To: Guy Labrecque
From: Mike Nugent
Fax: 774-4016
Date: August 14, 2002
Phone: 774-4441
Pages: 1
Re: Carvel Building /H.P.Hood (066 A010) **CC:** Paul Becker

• • • • •
In reviewing the plans for the Bottle Manufacturing Facility, I have a few questions;

**FLOOR PLAN**  
1/8"=1'-0"

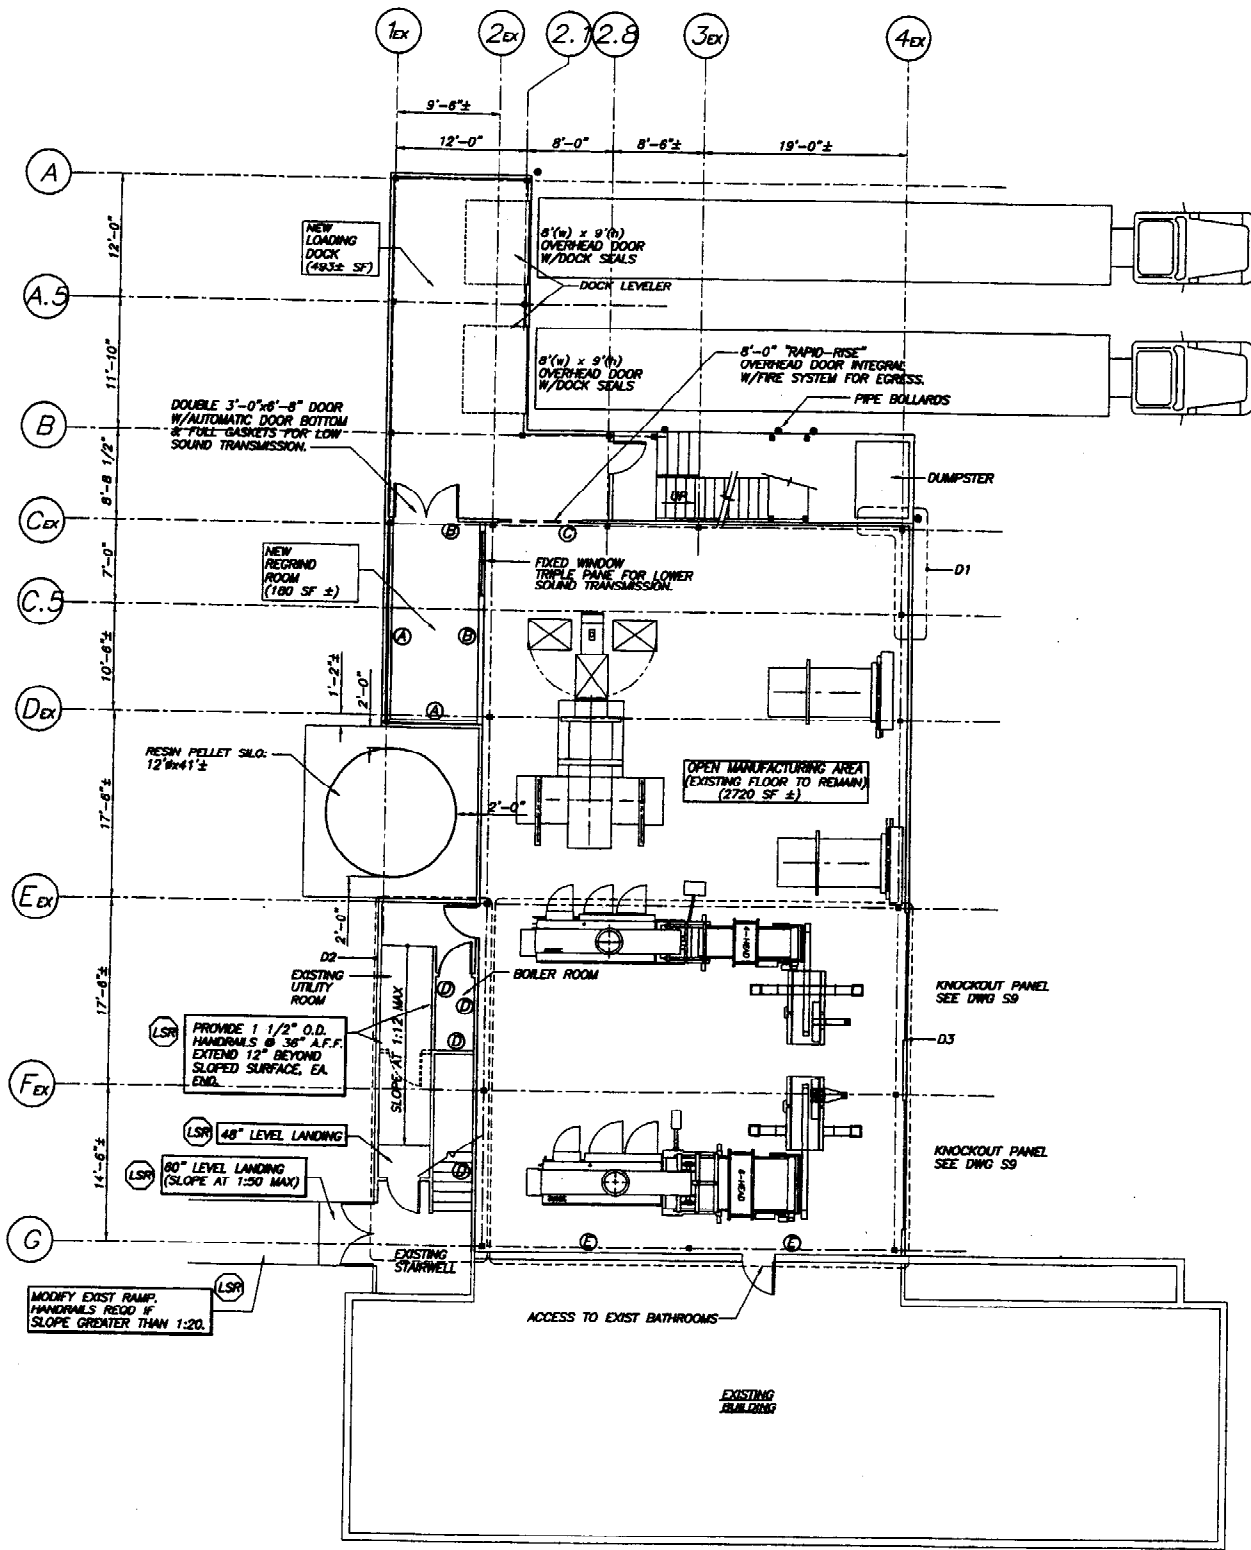
- 1) The second means of Egress seem to be an overhead door. I find no provisions in Section 1017.4 of the BOCA Code that allow an overhead door as a means of egress doorway. The other door appears to go to a restroom, according to the submission.
- 2) We had discussed an existing headroom issue on the catwalk door, how much headroom did we end up with?
- 3) A Statement of Special Inspections is required pursuant to Section 1705. for the applicable components of construction.
